TR010064: Application by National Highways for the M60/M62/M66 Simister Island Interchange Project

The Examining Authority's Written Questions and requests for further information

Issued on 22 October 2024

Reproduced by permission of Ordnance Survey on behalf of HMSO.
 © Crown copyright and database right 2022. All rights reserved.
 Ordnance Survey Licence number 100030649.

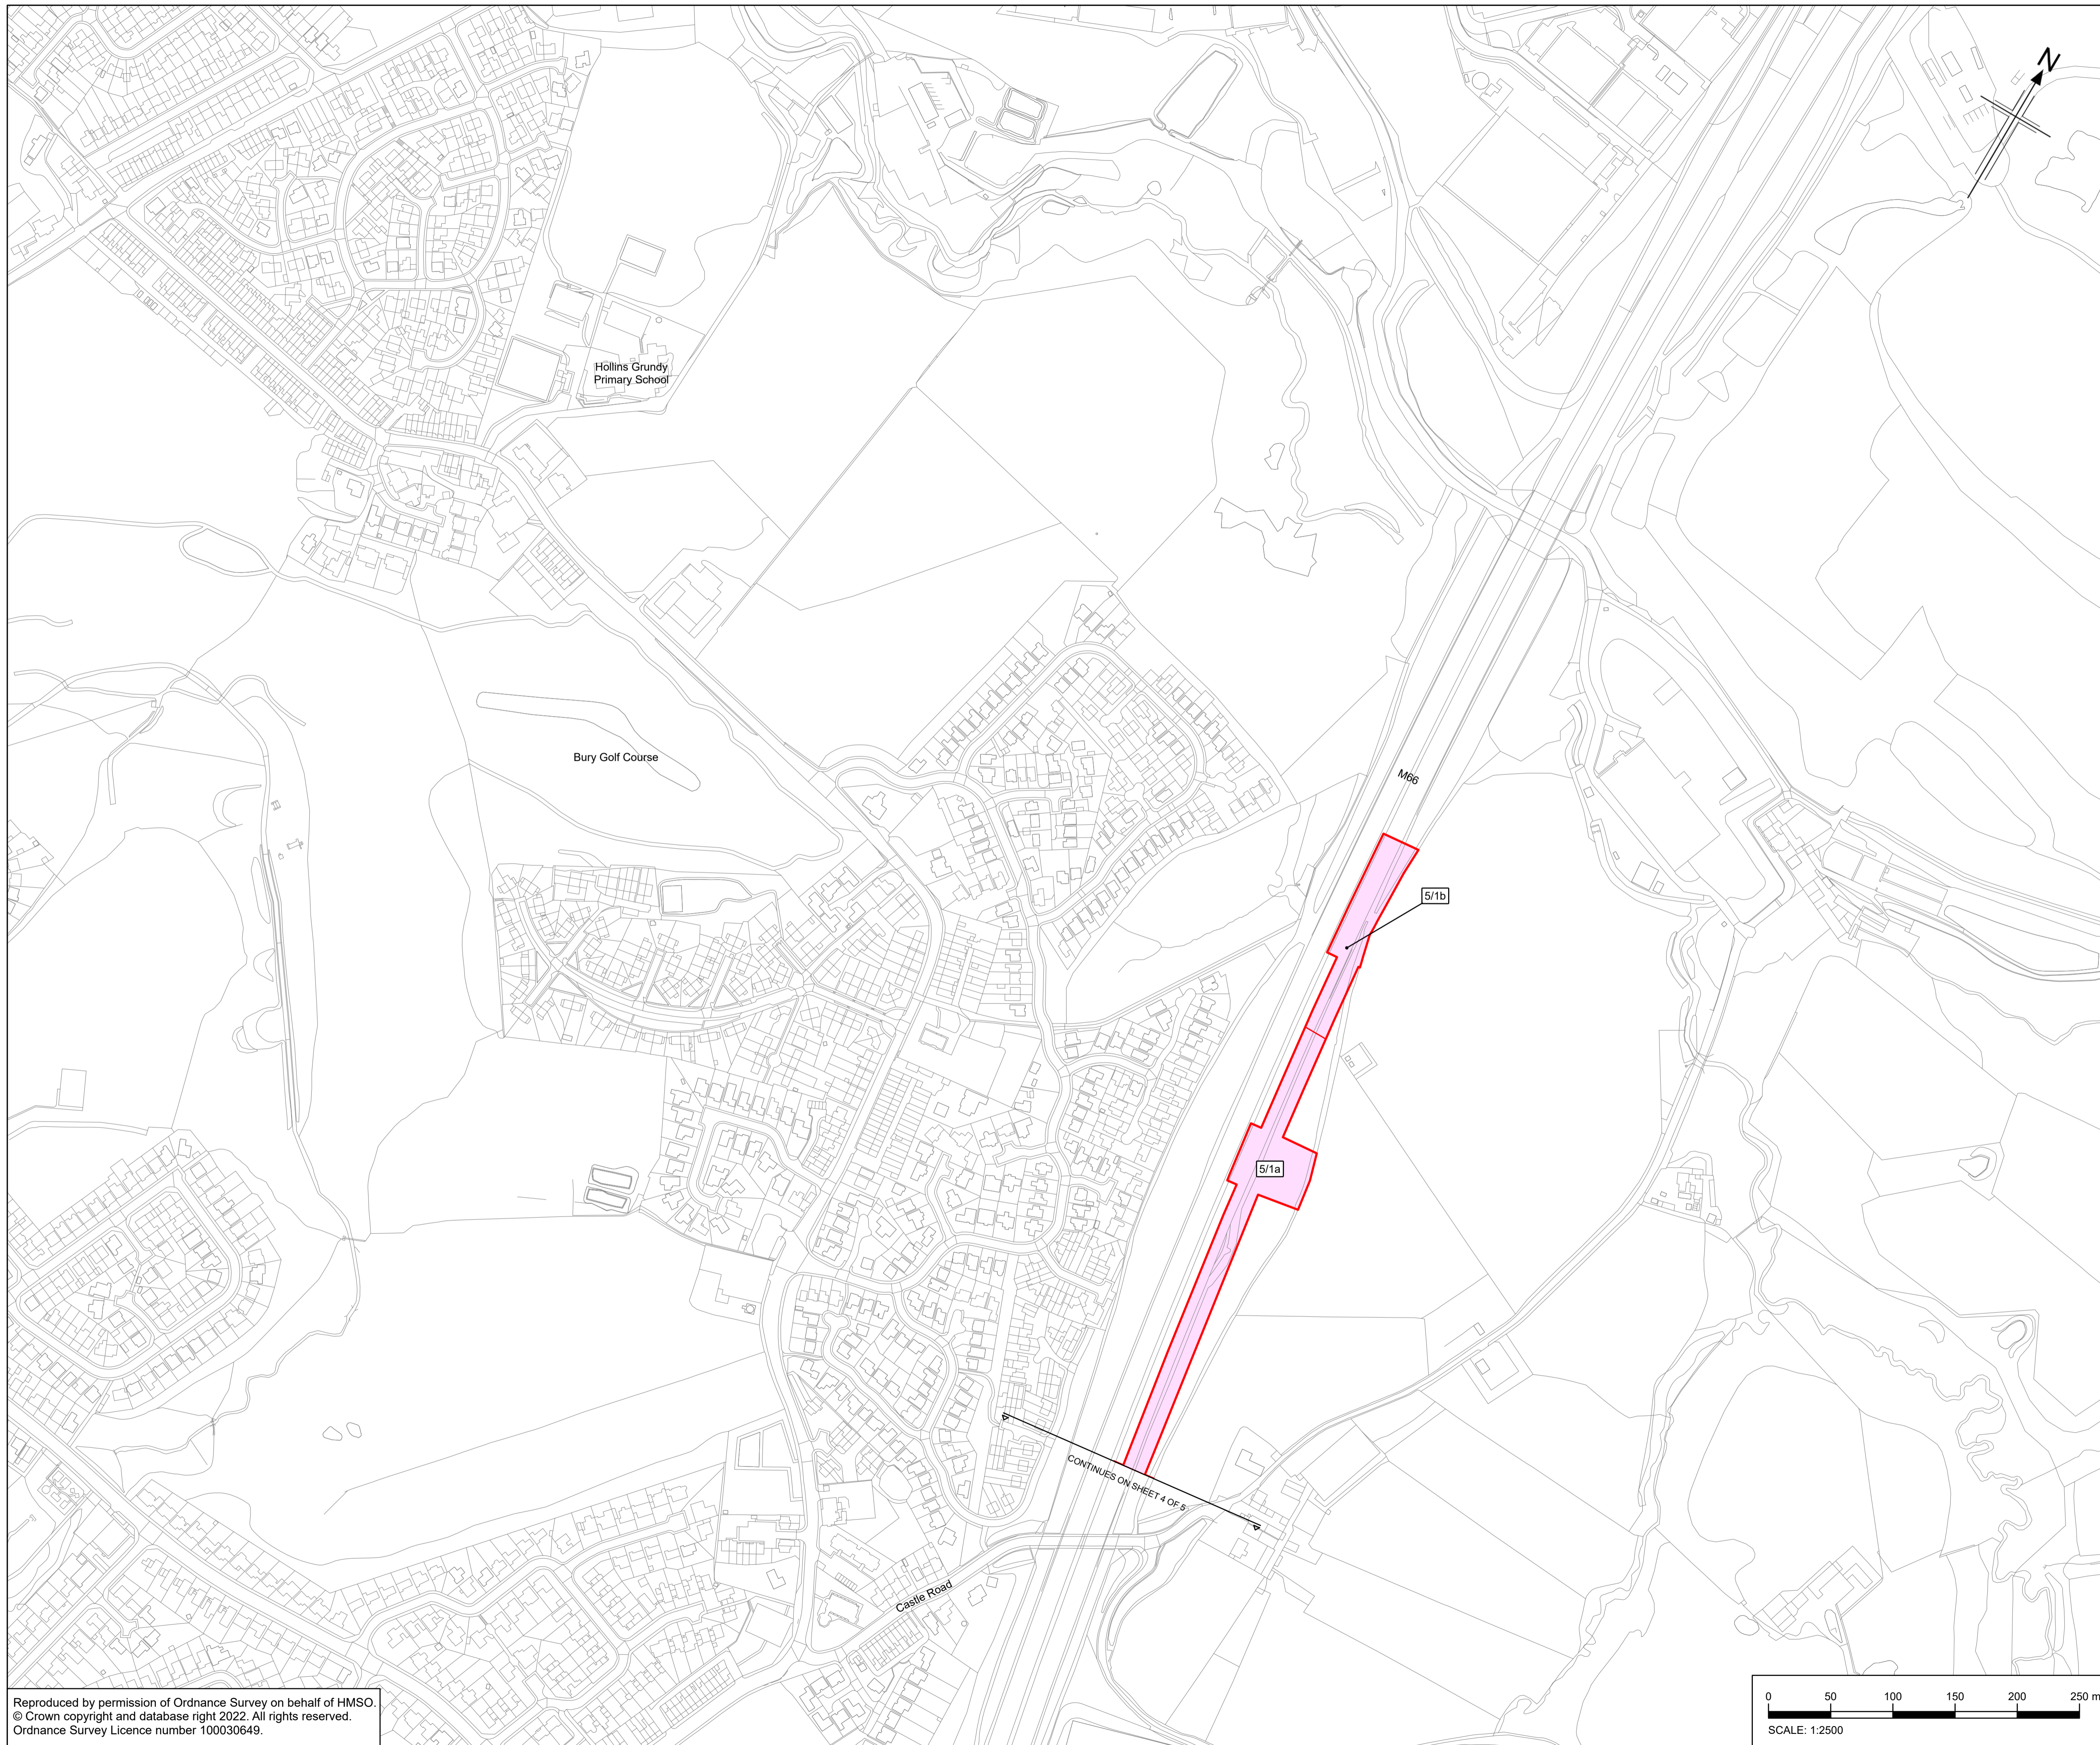
ExQ1	Question to:	Question
CA.1.2	Applicant	<p>Category 3 Persons</p> <p>The Statement of Reasons (SoR) [APP-019], Section 4.7 briefly covers the assessment of Category 3 persons explaining that it was based on a worse-case assessment. The process is described in the BoR [AS-010].</p> <ol style="list-style-type: none"> i. Please provide further details of the process for identifying Category 3 persons. ii. Please provide a map showing the locations of Category 3 persons. iii. Explain why the assessment can be considered 'worse-case'.
CA.1.3	Applicant	<p>Unknown/Unregistered Land</p> <p>Diligent enquiry into land interests: Could you summarise where you have not yet been able to identify any persons having an interest in the land, including any Rights over unregistered land? What further steps will you be taking to identify any unknown Rights during the Examination?</p>
CA.1.4	Applicant	<p>Land Plans</p> <p>There is no plot 3/3 but there are two plots marked 3/4 on the Land Plans [AS-005]. Please correct.</p>
